ICC Hotel, Response to NSW Department of Planning & Environment queries

Please find below our responses to each of the queries as raised by NSW Department of Planning & Environment.

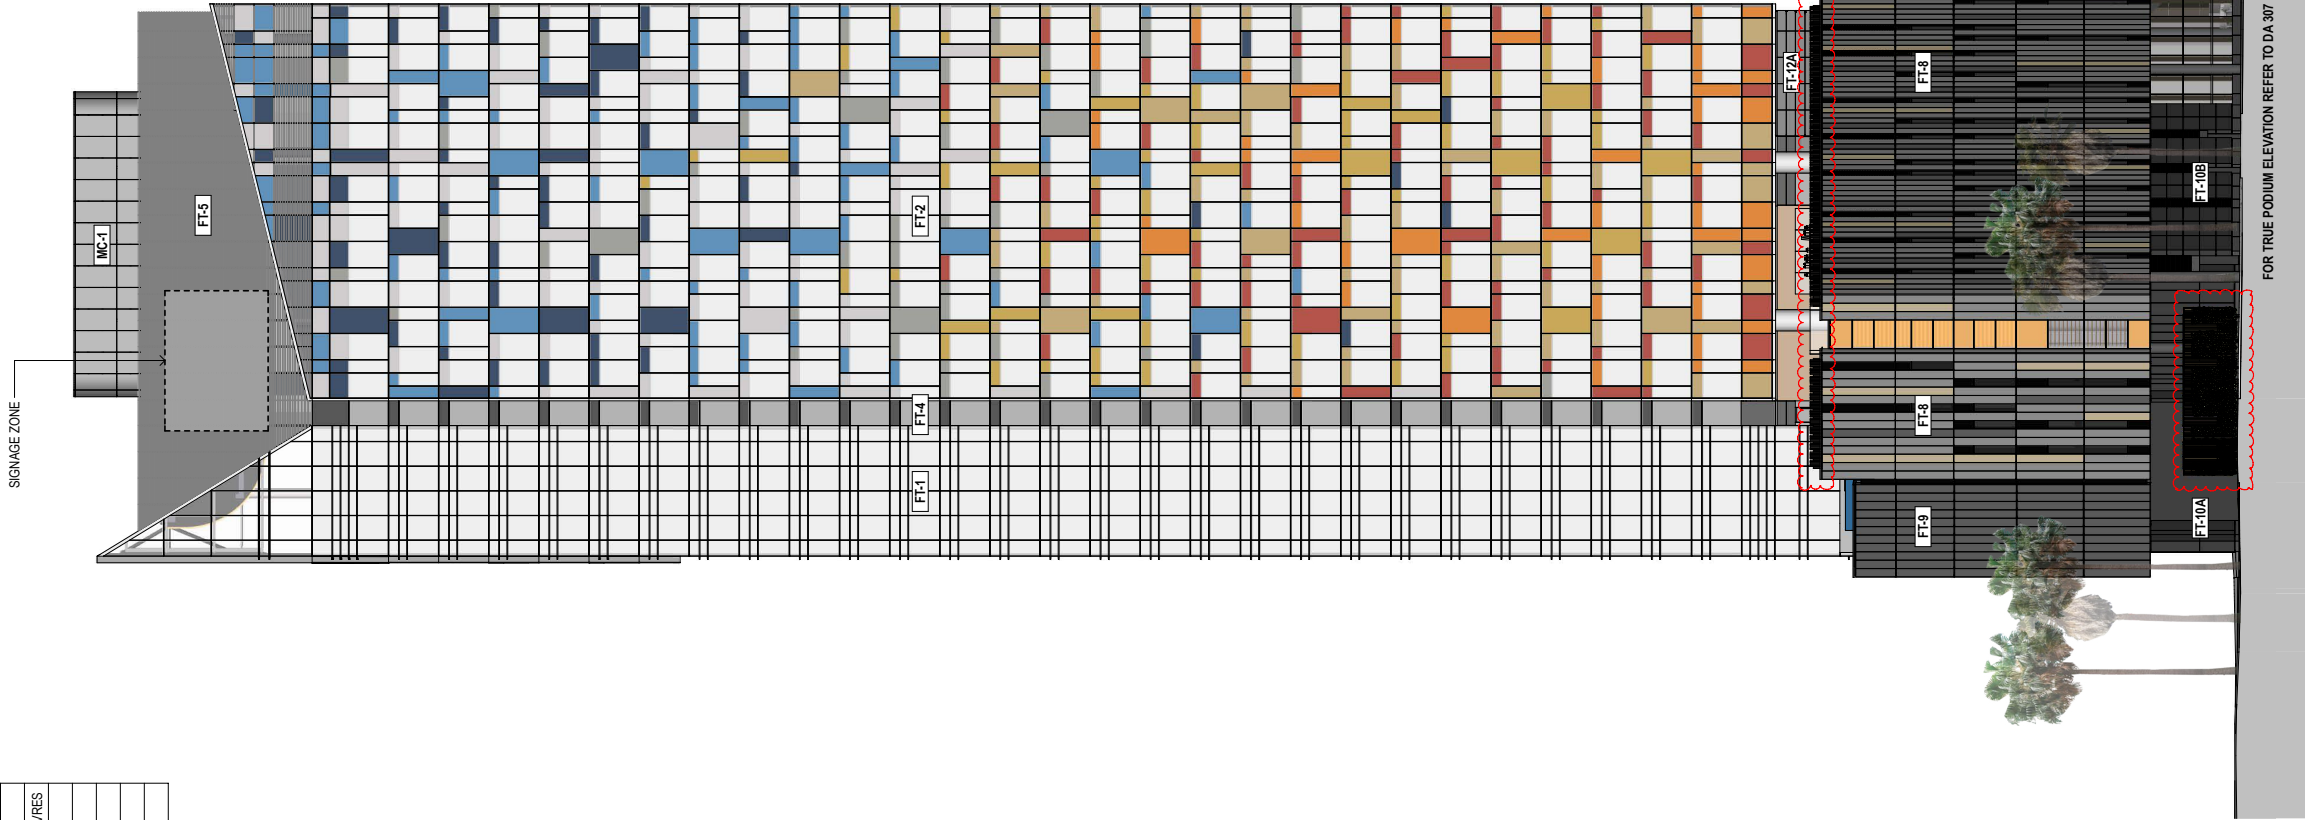
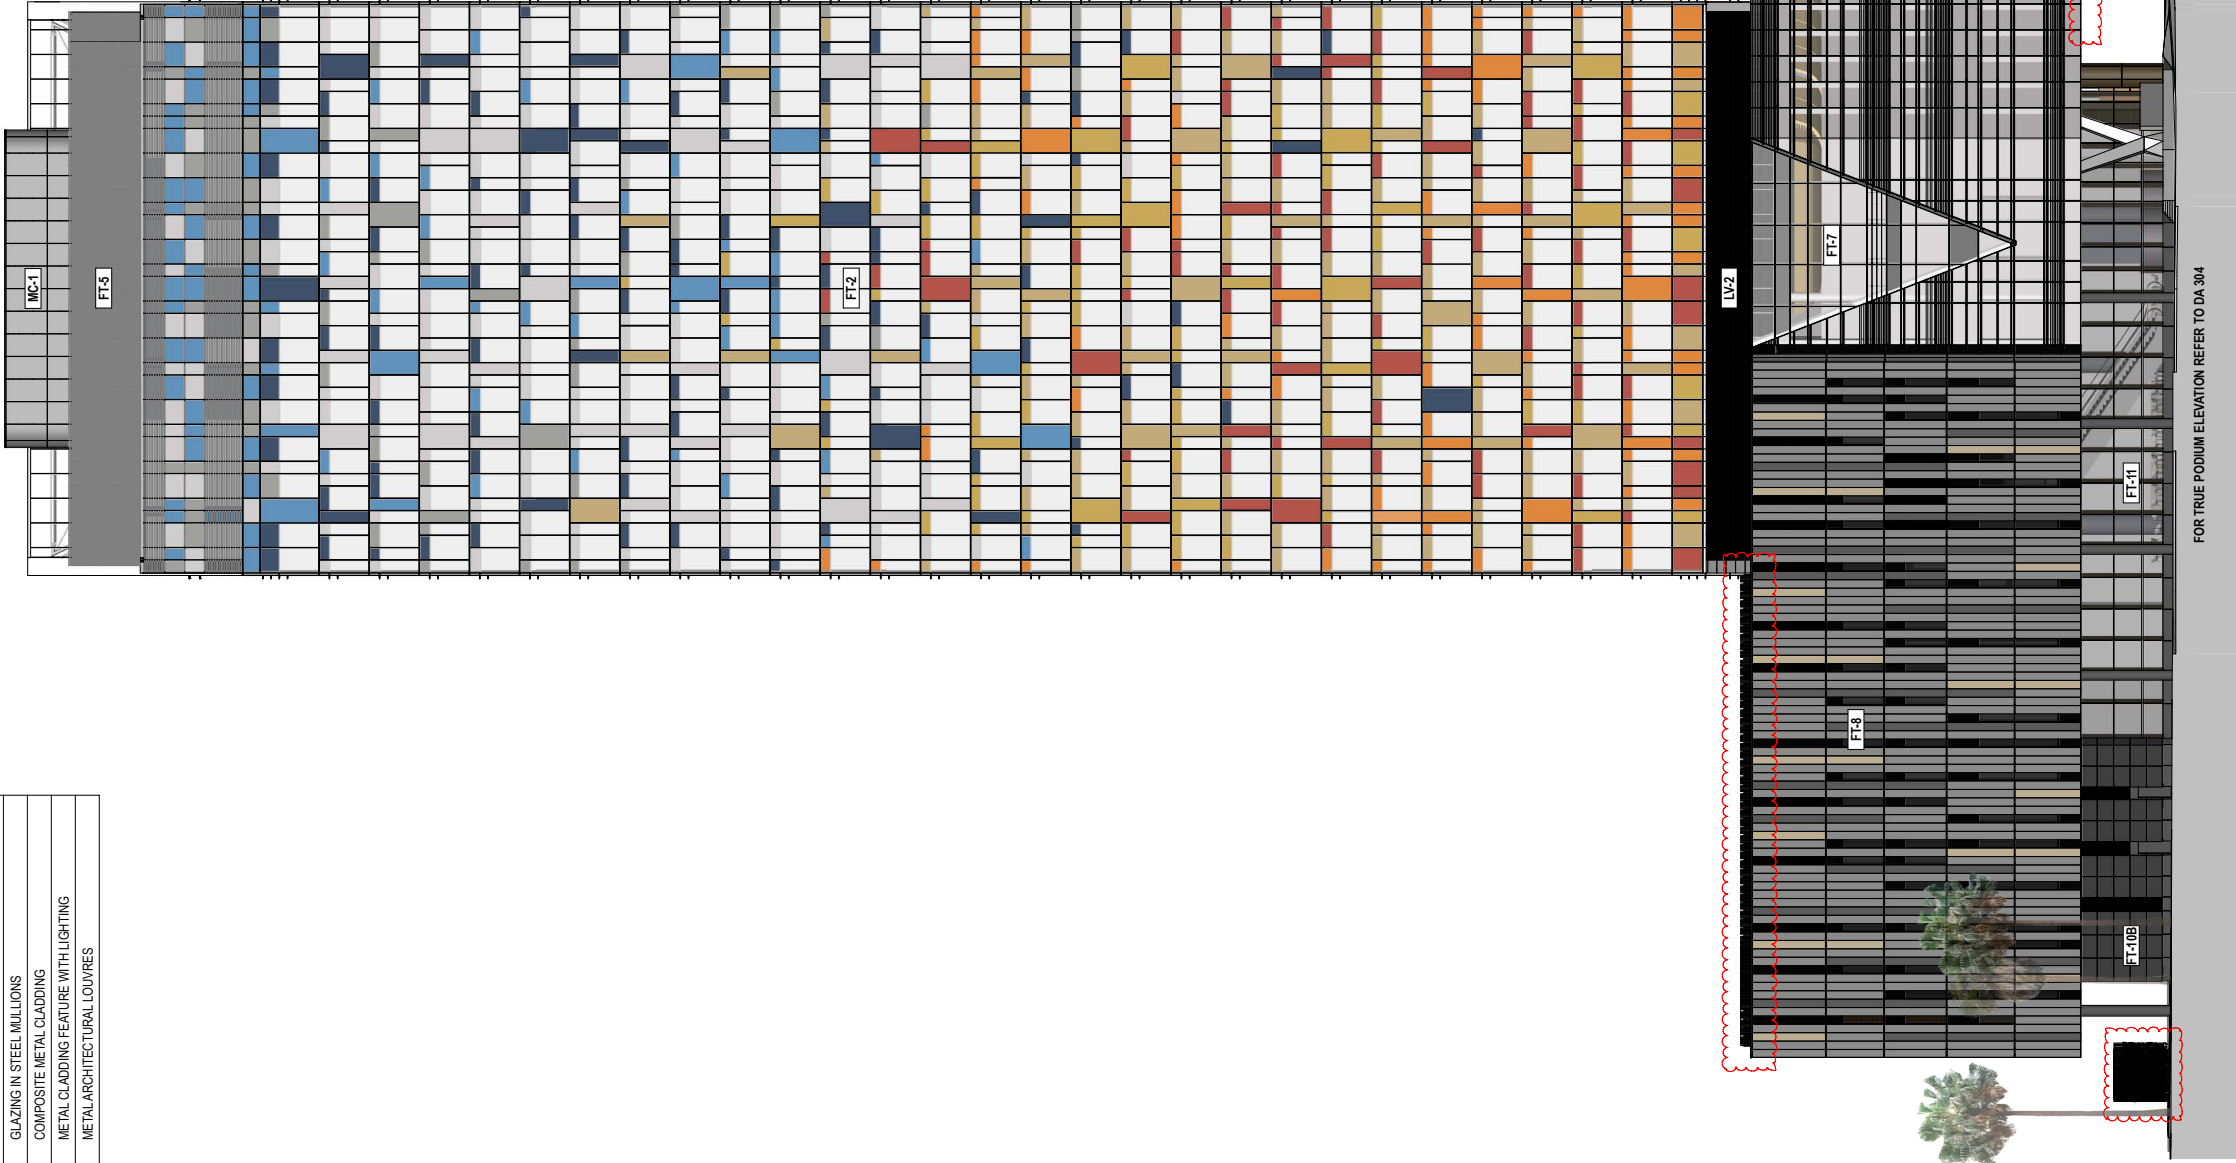
- a) The roof top plant room has been increased in size and is taller than the top of the lantern RL 133.500;

The increase in RL on the original submission was a drafting error. The DA approved maximum RL of 133.500 has been corrected in the revised architectural pack. The width of the plant room has increased slightly in order to conceal the building maintenance unit (BMU) which was originally planned to be mounted on the roof but not enclosed.

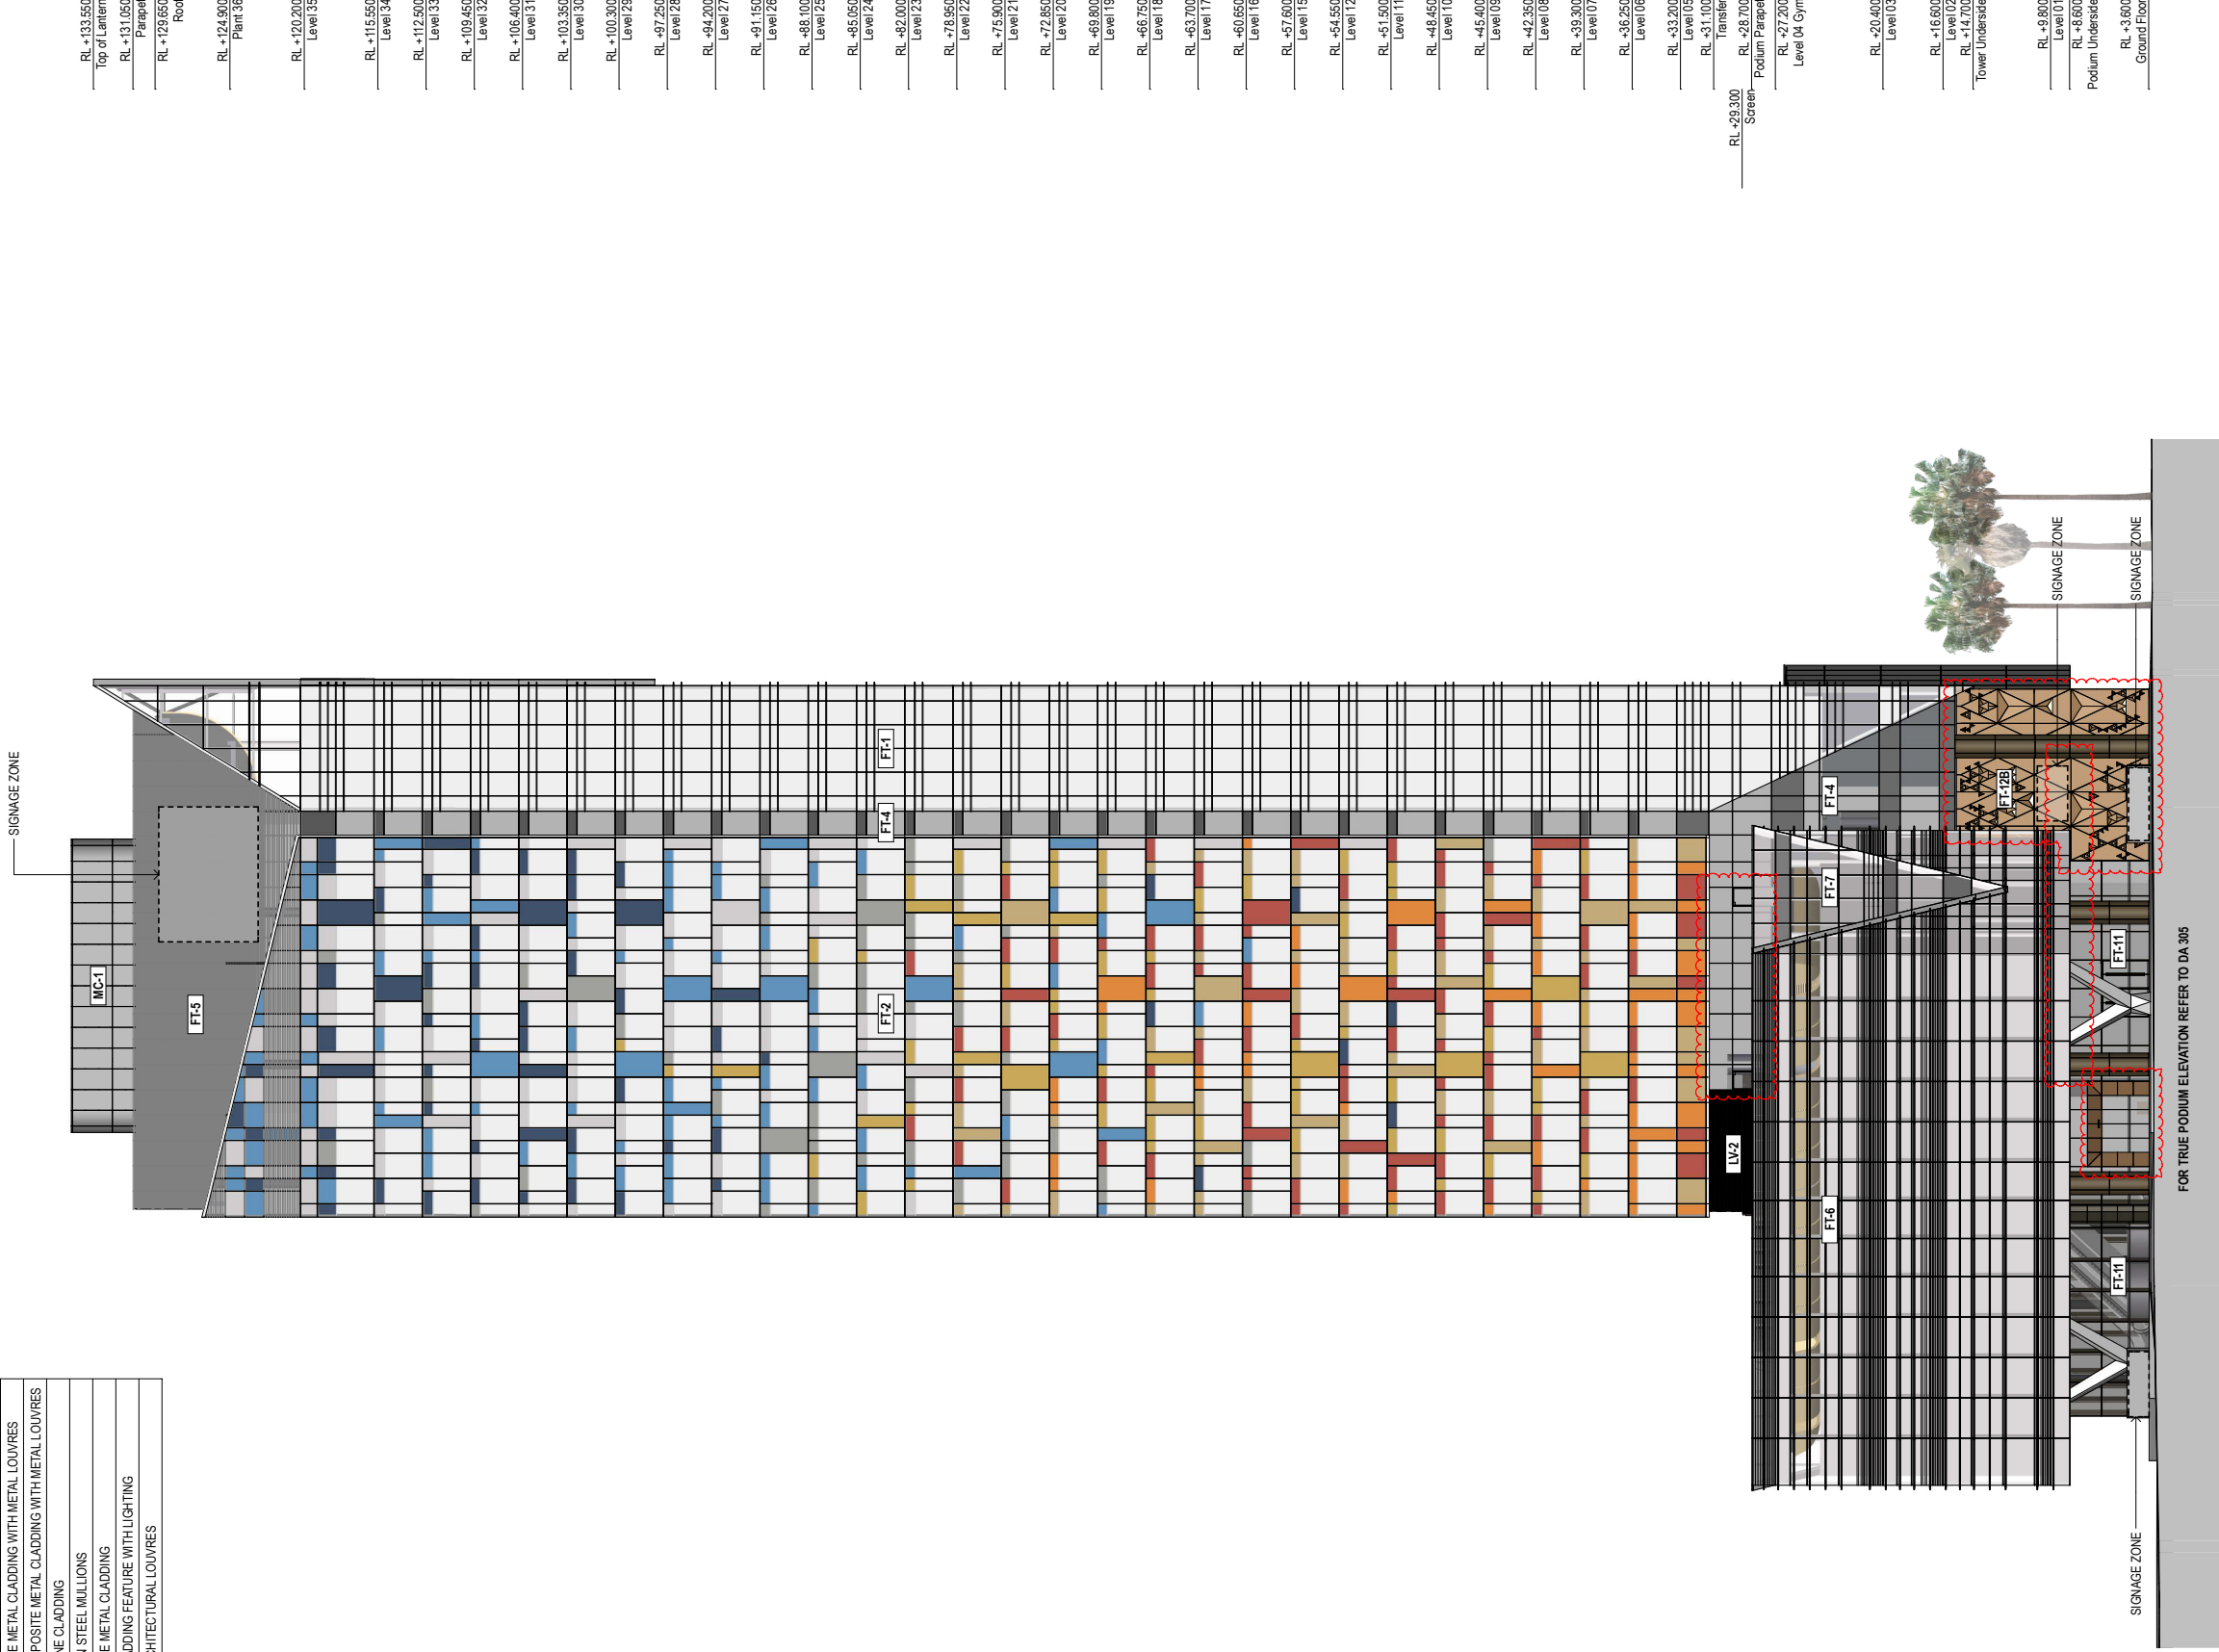
- b) On the front elevation (DA300), dark panels are shown at lower levels and a thick stripe is shown at the upper levels and it is unclear what these elements are (see attached annotated elevation);

The grey areas at the lower levels and thick stripe were shown in error (CAD / printing process) and have been removed.
